**Consultation Response from KC,
Lead Local Flood Authority**

**2022/91598 former, Stile Common Infant & Nursery School, Plane Street, Newsome,
Huddersfield, HD4 6DF**

Date Responded: 14 June 2022

257/05/03

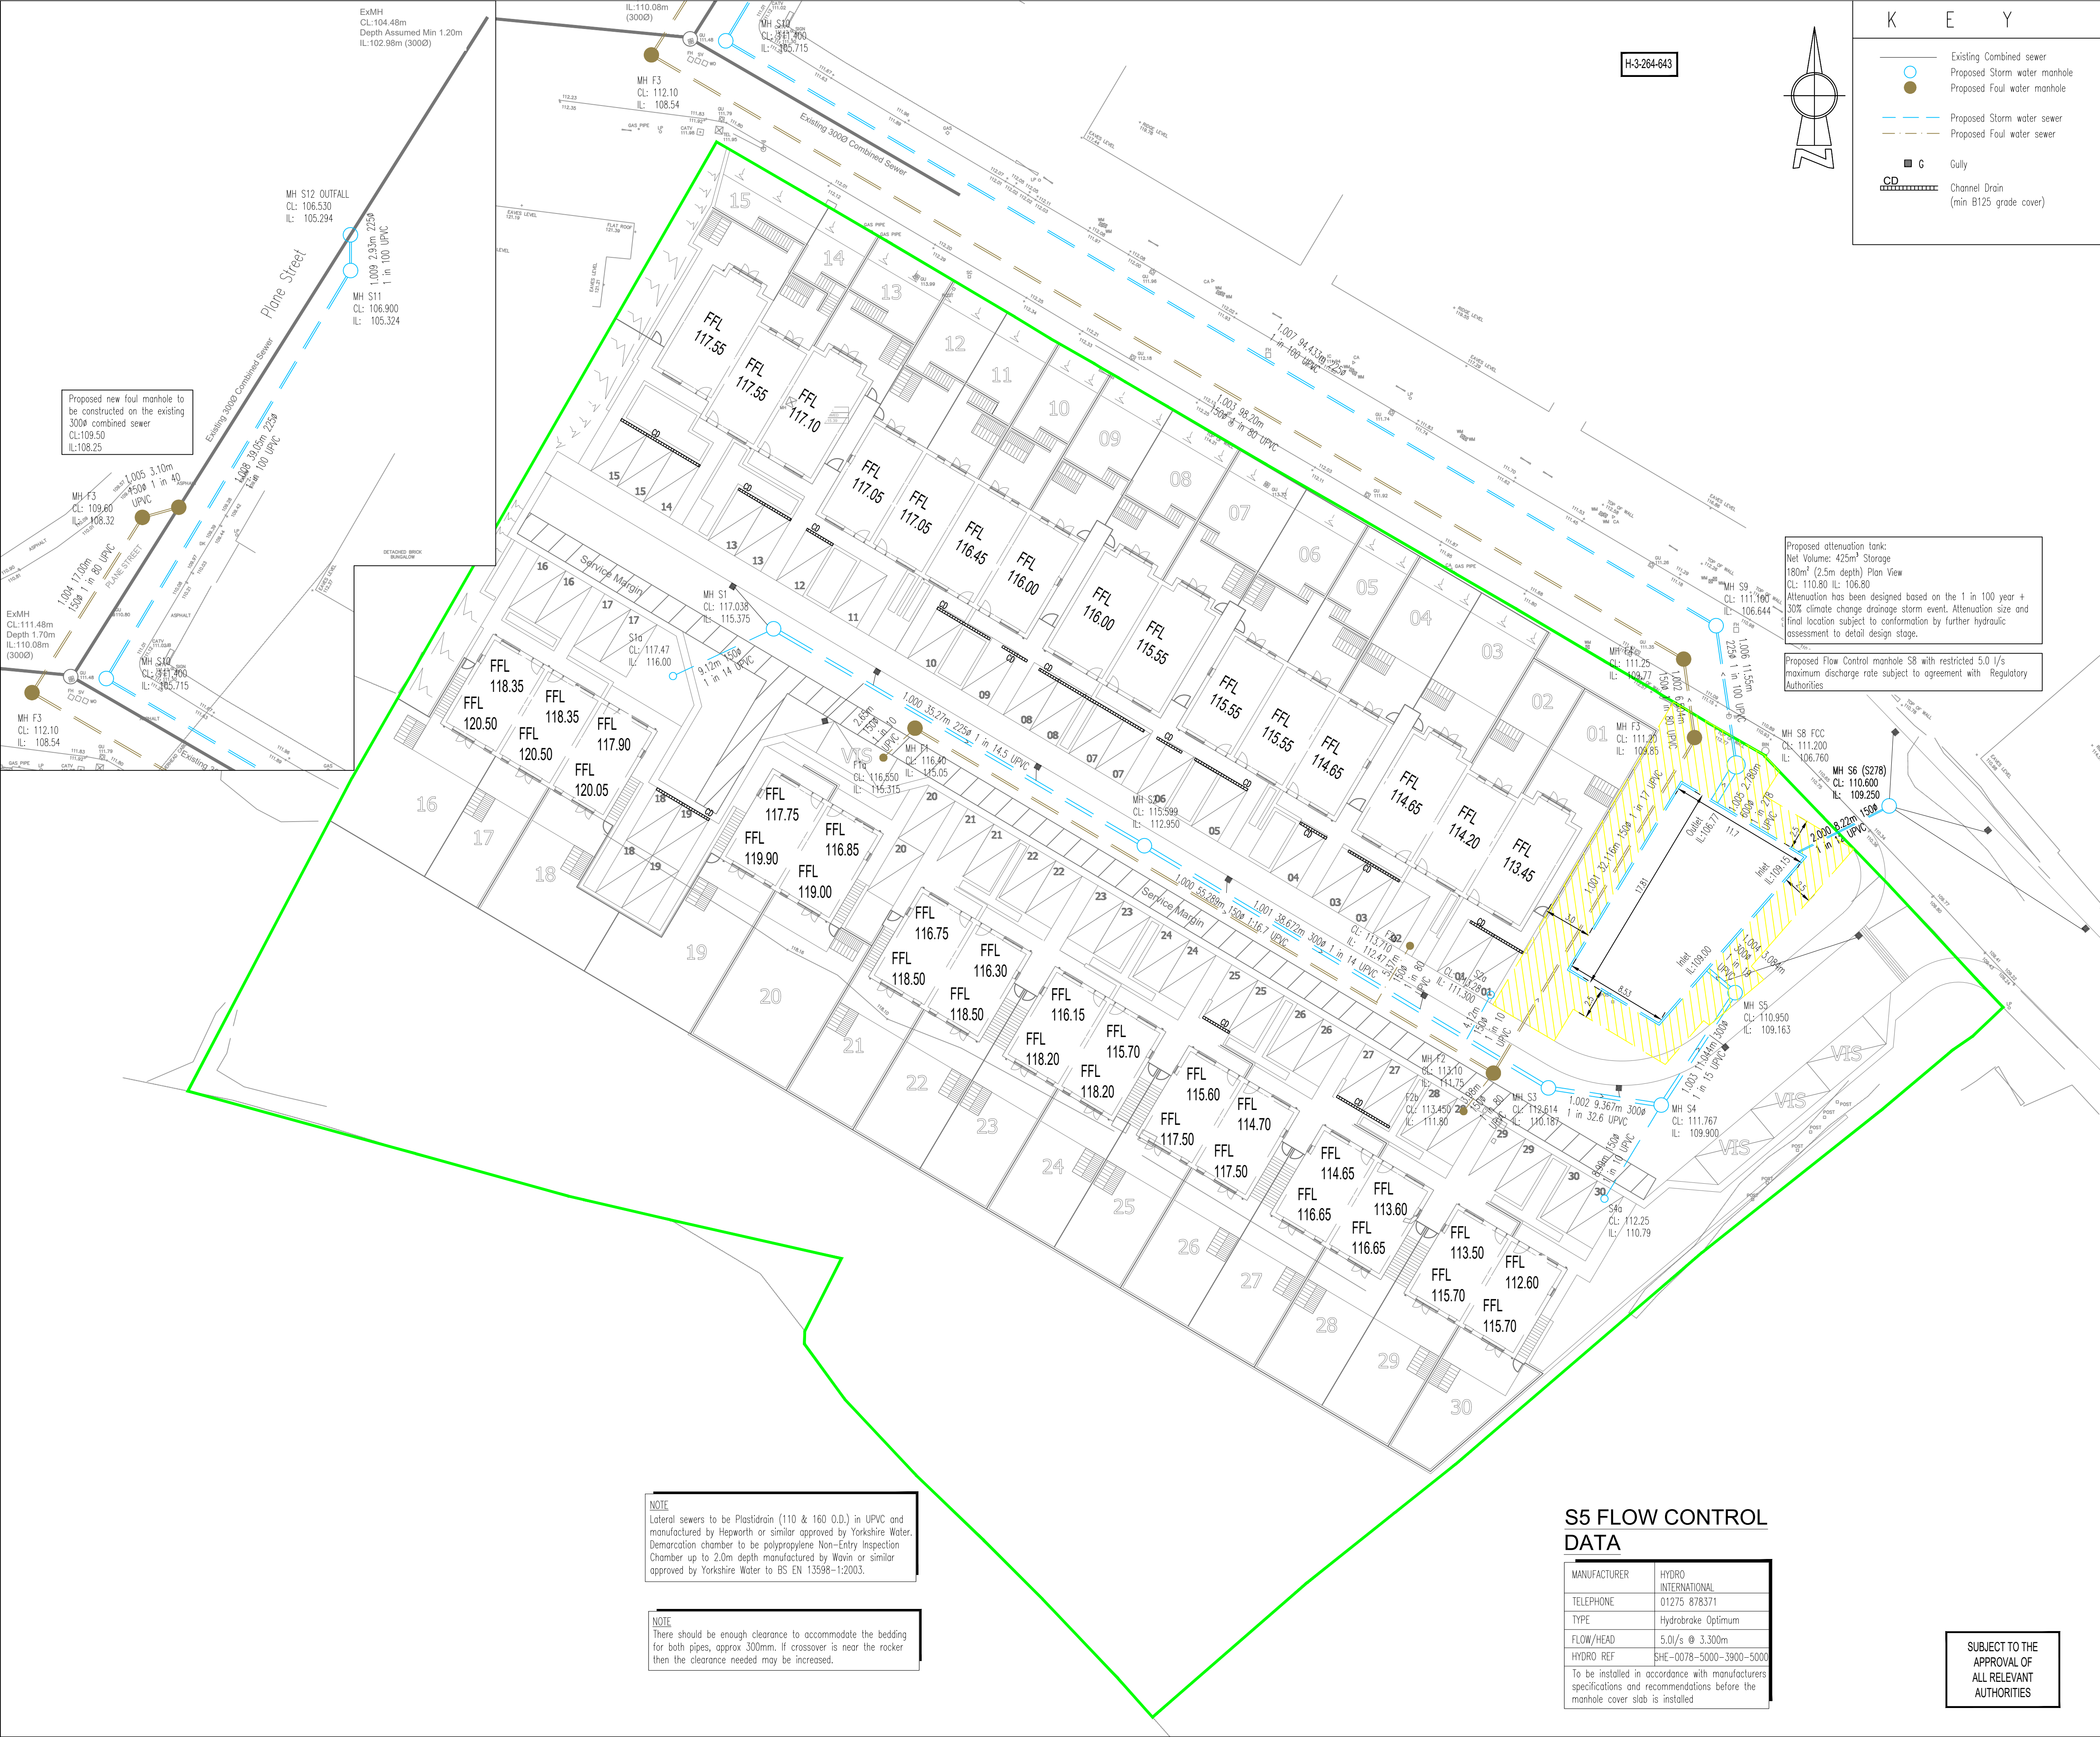
The previous LLFA consultation response dated 02 September 2020 requested further information regarding the proposed surface water drainage scheme including a condition survey of the surface water drain in Plane Street (via MH C1 on drawing 0257/05/03). This information appears to have not been submitted. A CCTV survey of the existing drain should be supplied to the Planning Officer to indicate the condition of the pipework.

Therefore Condition 16 **cannot be** discharged until this information has been received.
